**BR/63/22/PL**

Salisbury House The Steyne Bognor Regis PO21 1TX

Change of use of 5 No self-contained flats for adults with learning difficulties to 5 No self-contained flats and formation of 5 No further flats from HMO rooms, garage and office, repairs and decoration of external surfaces, minor alterations to elevation facing Sadler Street, change one window facing rear courtyard to French doors & apply obscure film to 2 windows in courtyard area. This application affects the setting of listed buildings, affects the character & appearance of The Steyne Conservation Area and is in CIL Zone 4 (Zero Rated) as flats.

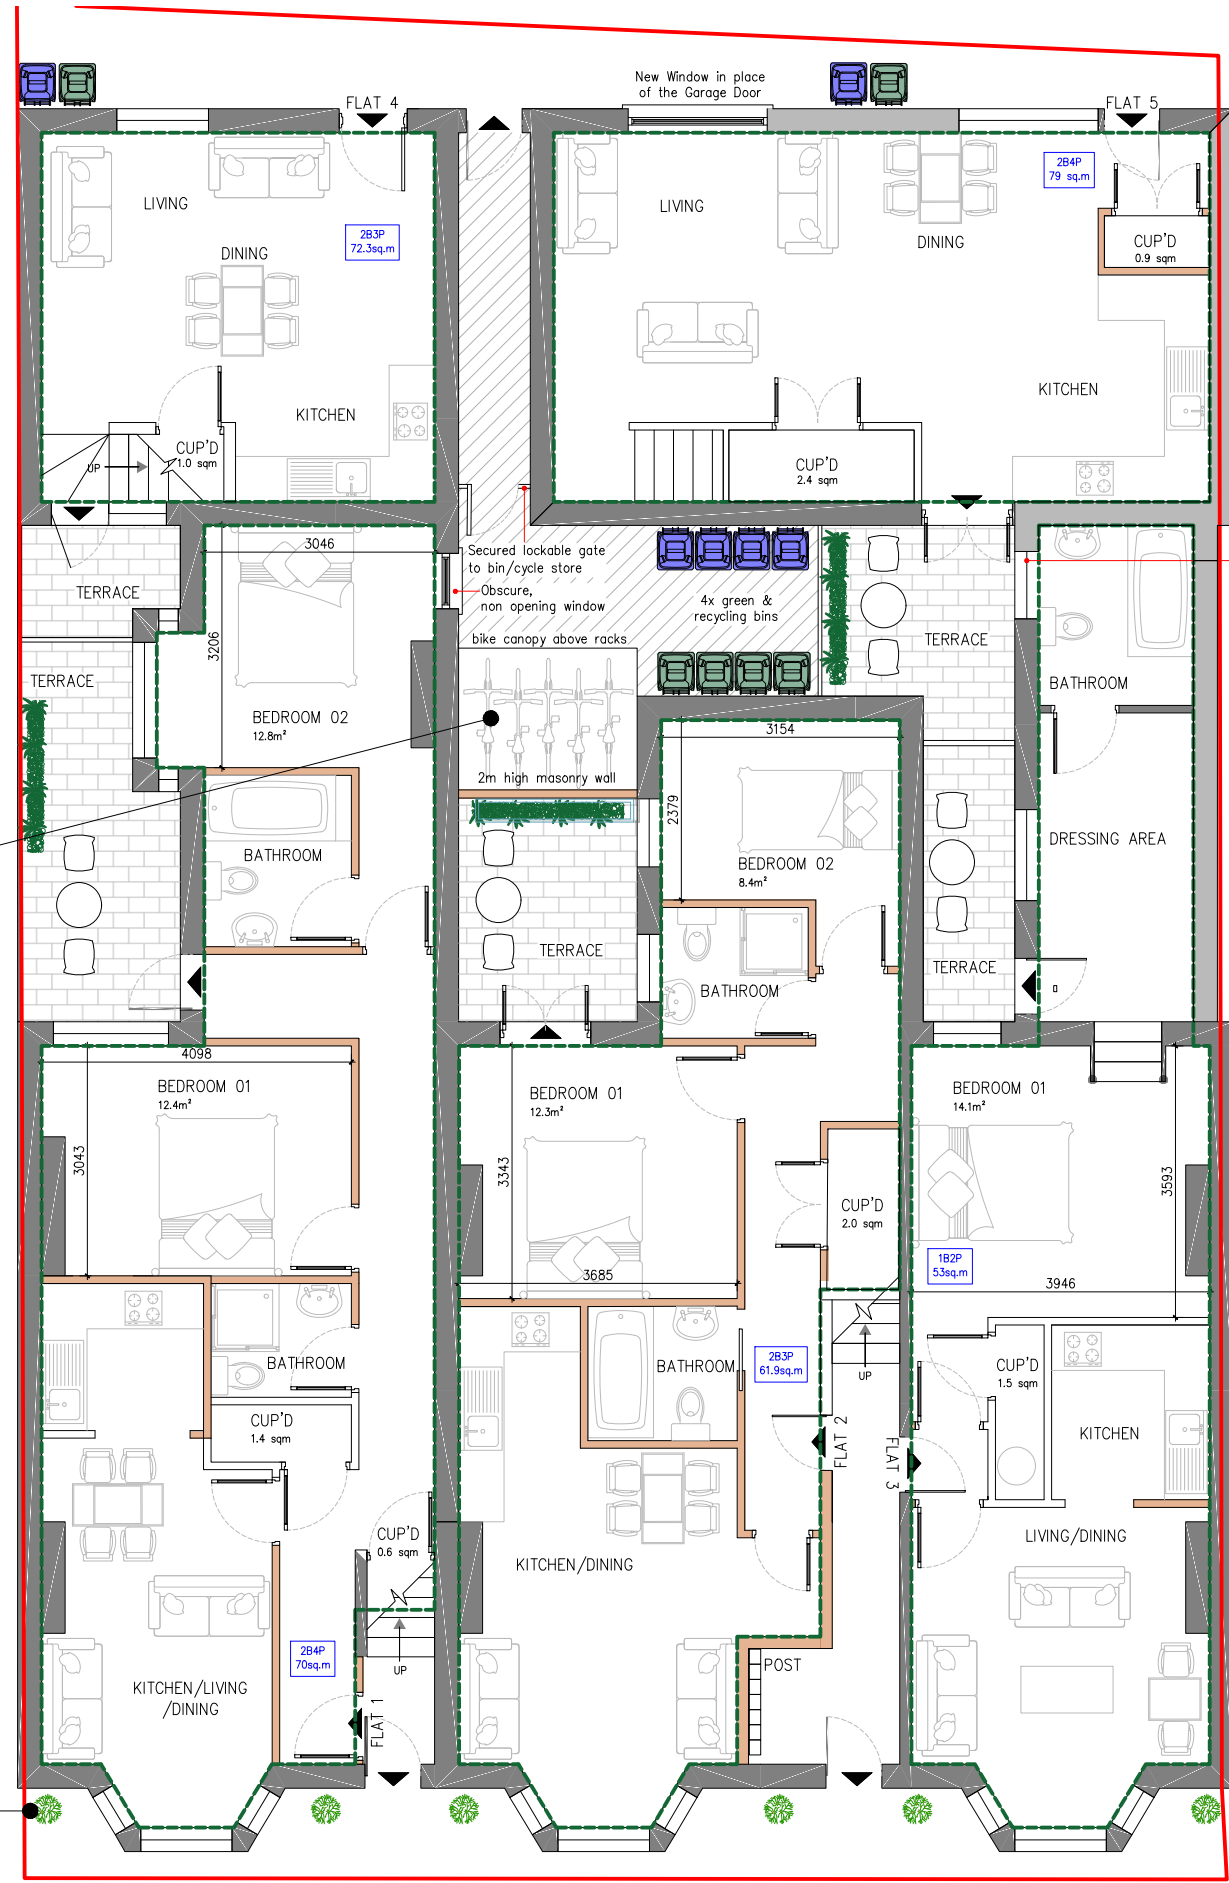
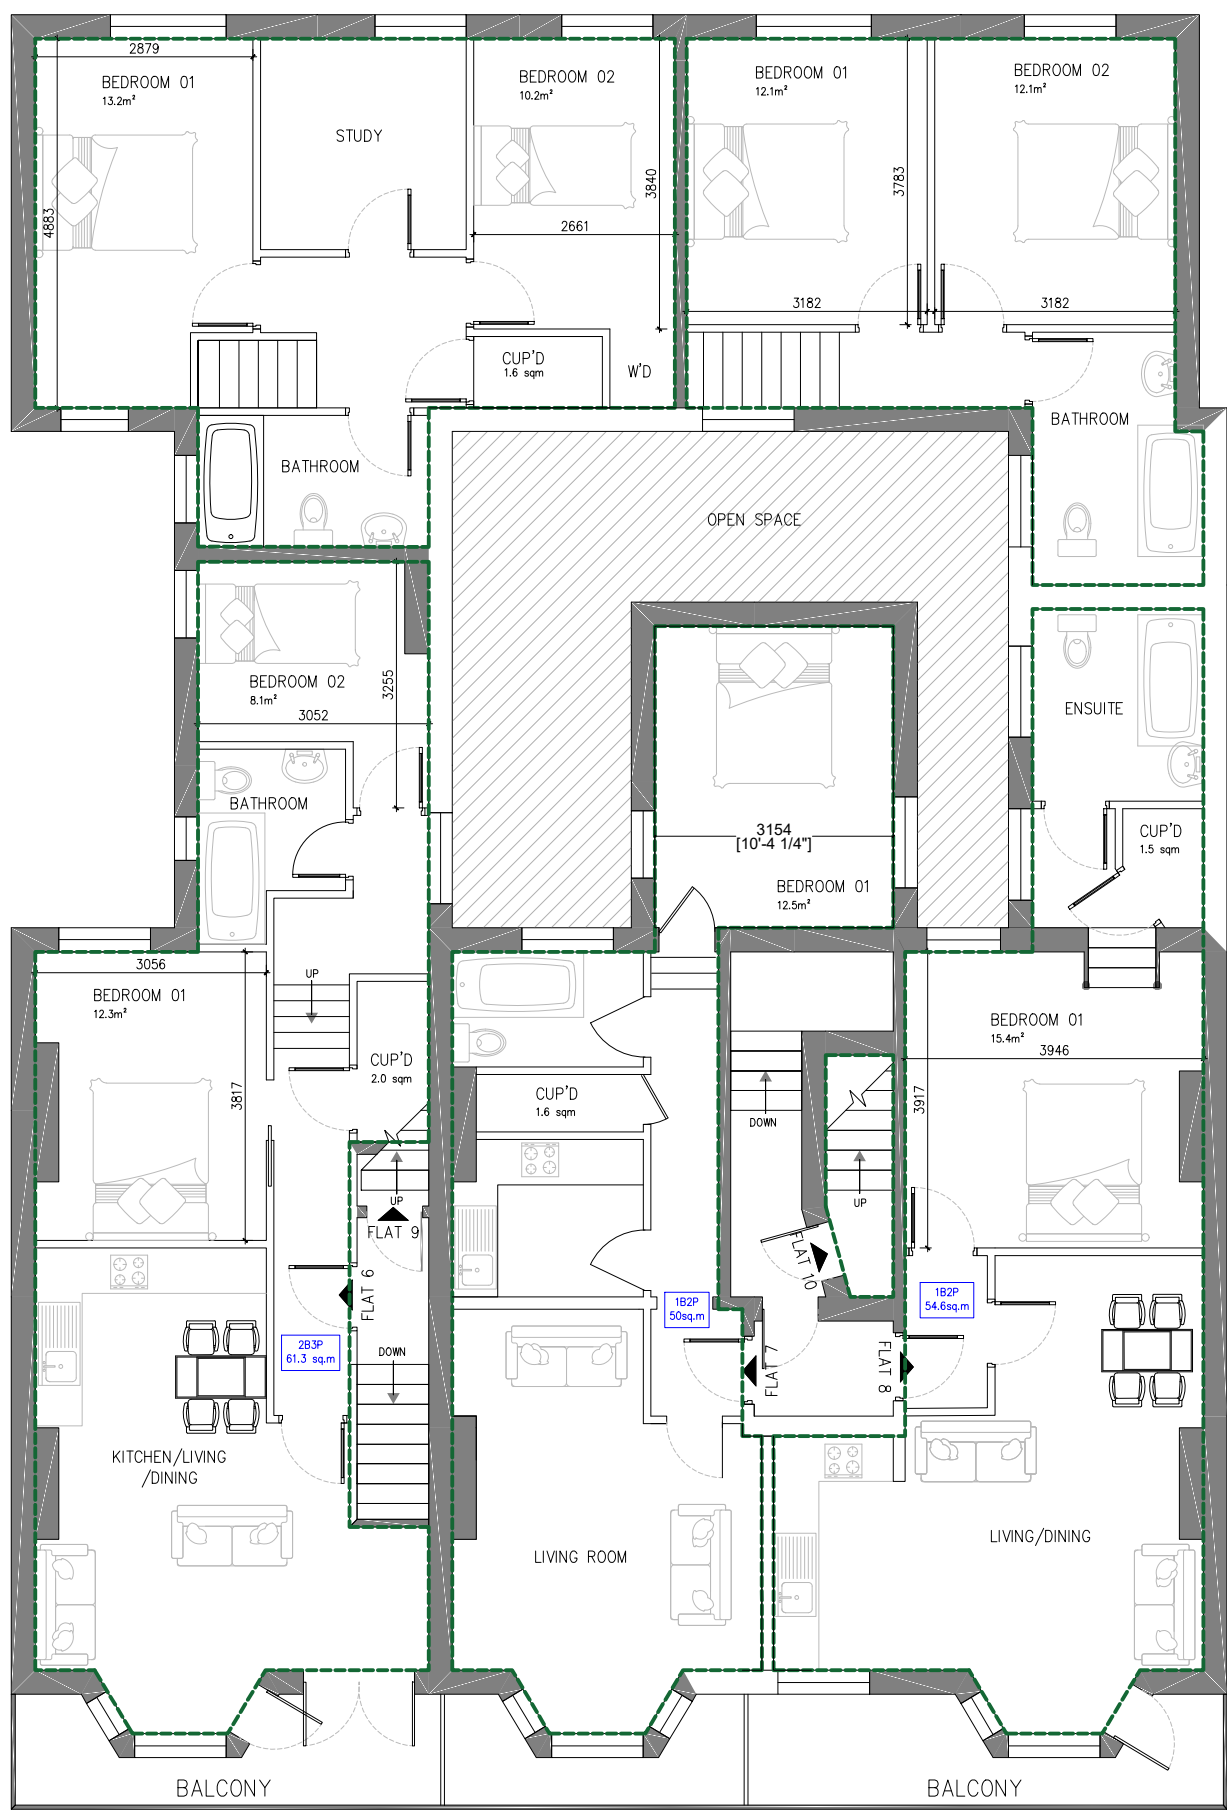
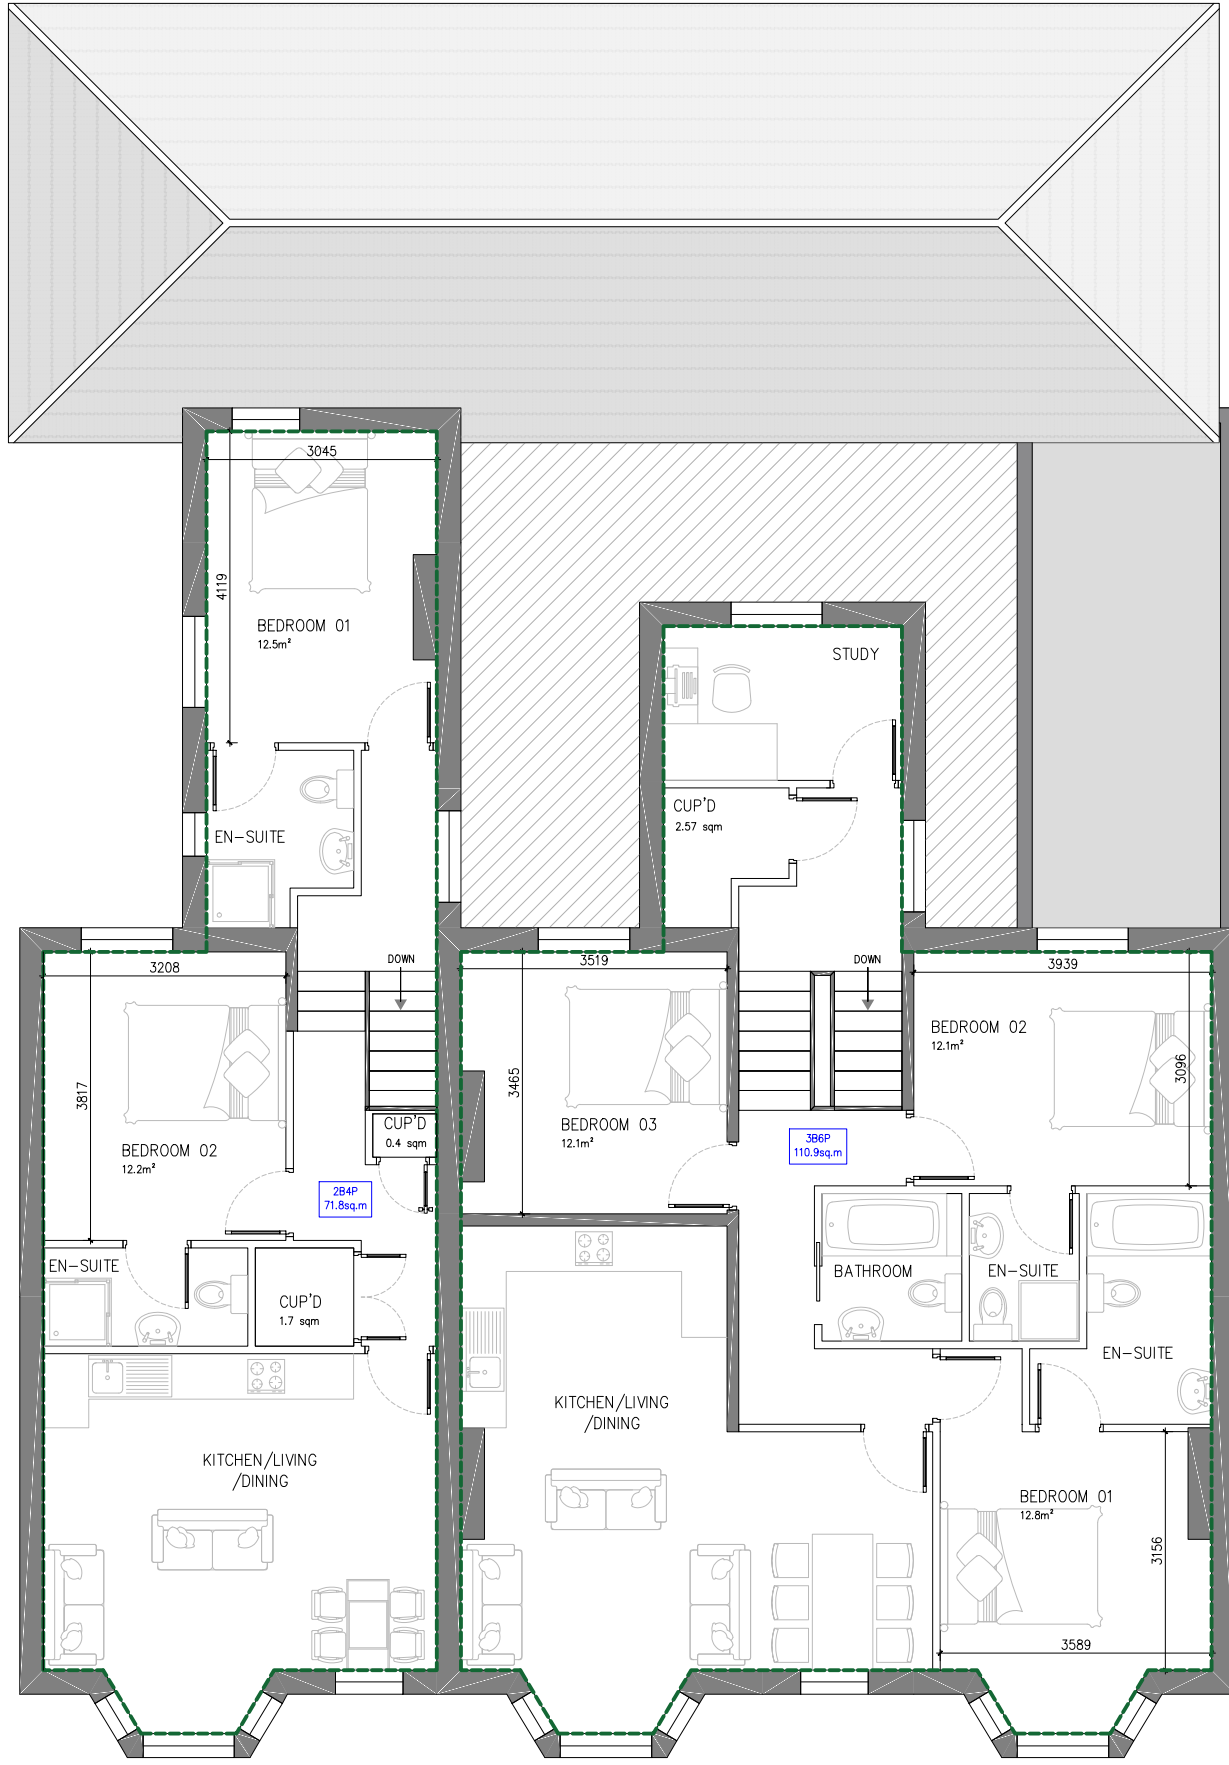
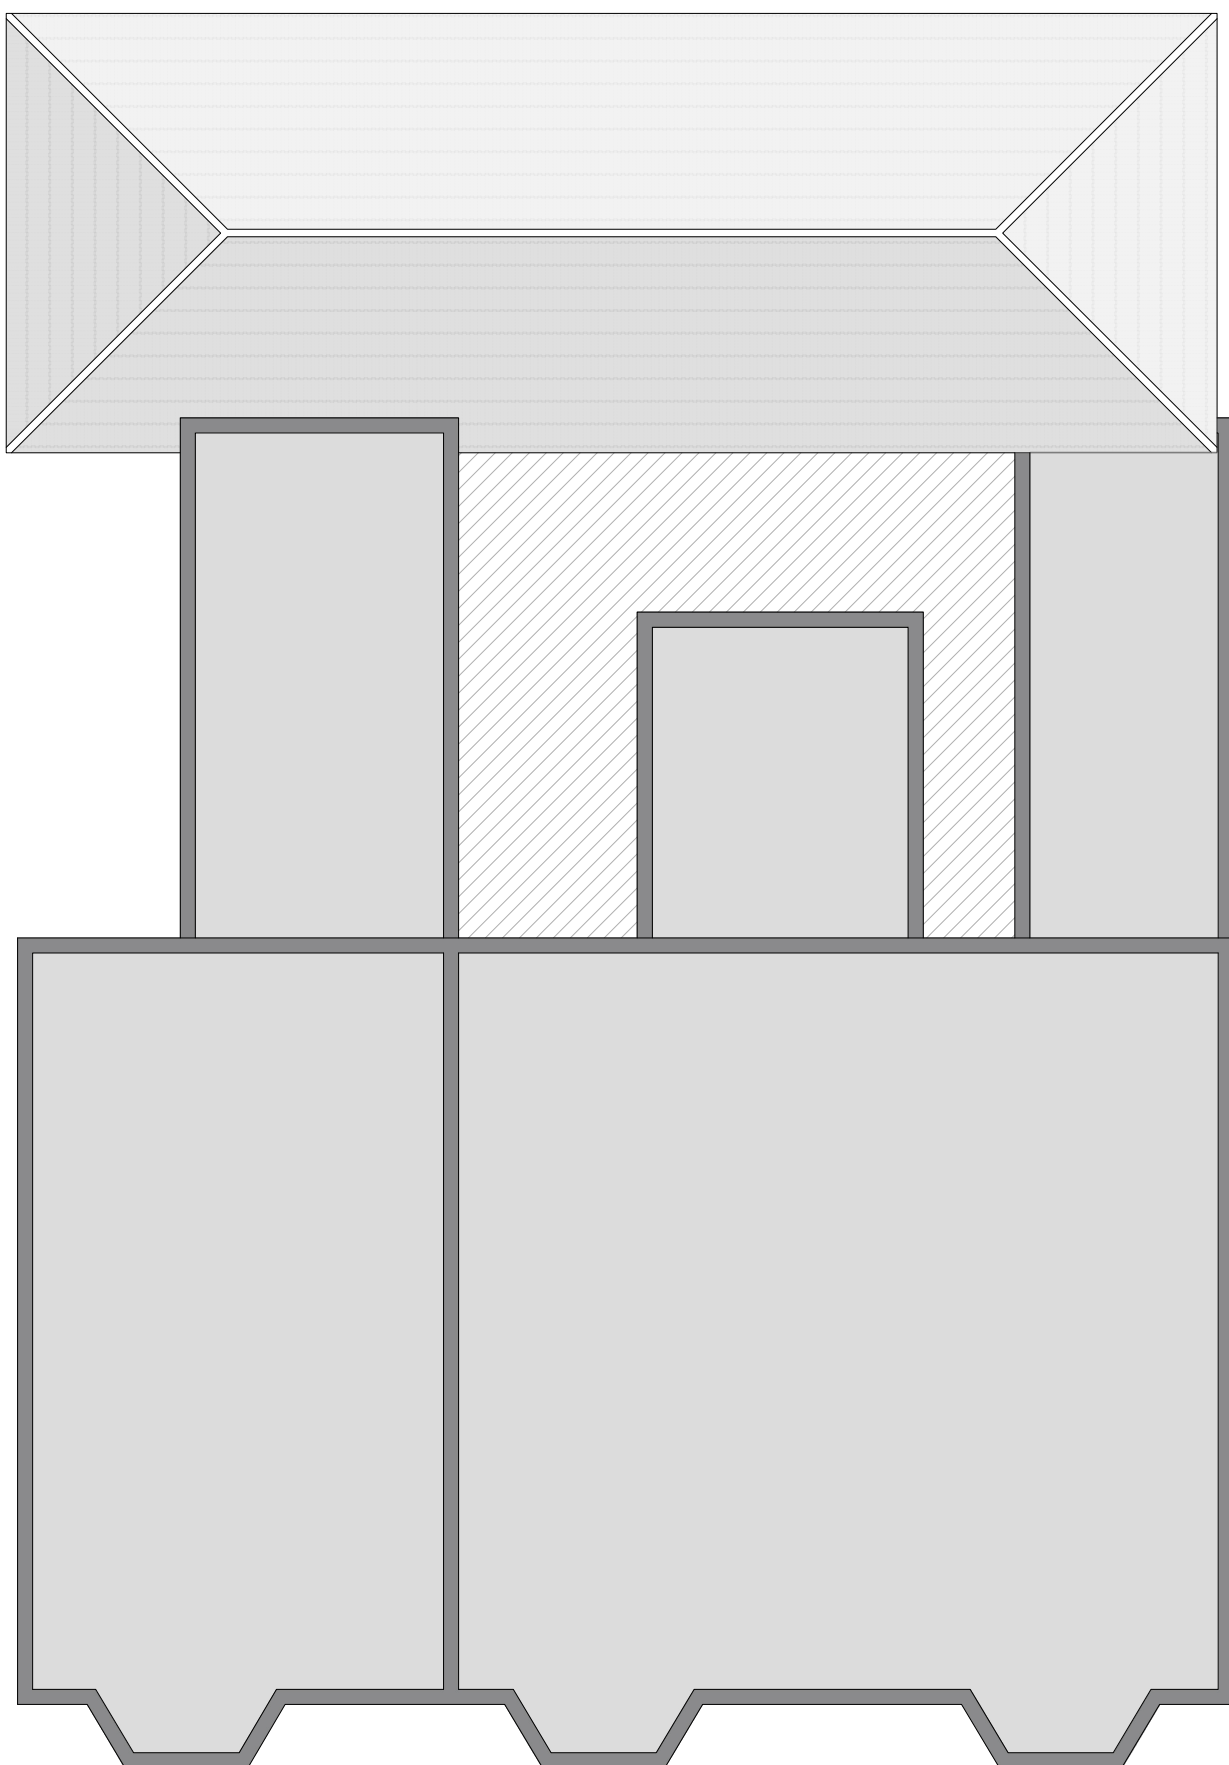
Having had the opportunity to review the plans, especially the existing and proposed floor plans it would appear that the proposal also includes extensive internal alterations to the layout which will involve the removal and/or relocation of a significant amount of walling. This will have a direct impact upon the current floor plan of the building, whose cellular layout can still be understood. Such a change is significant and harmful to the understanding of the buildings as formerly two separate homes (one of which was larger than the other).

The proposed works to the rear of the building are fairly minor in scale and would remove the existing garage door and a neighbouring window which are of poor quality. Whilst the creation of the new door opening would result in the loss of a small area of historic fabric, the area affected by this is minor. Subject to the design, materials and appearance of the alterations (including windows and doors) to the rear elevation, I am of the opinion that these are acceptable and would have a neutral impact upon the appearance of the building. Details of the windows and doors should be provided by way of condition, if you decide to recommend approval.
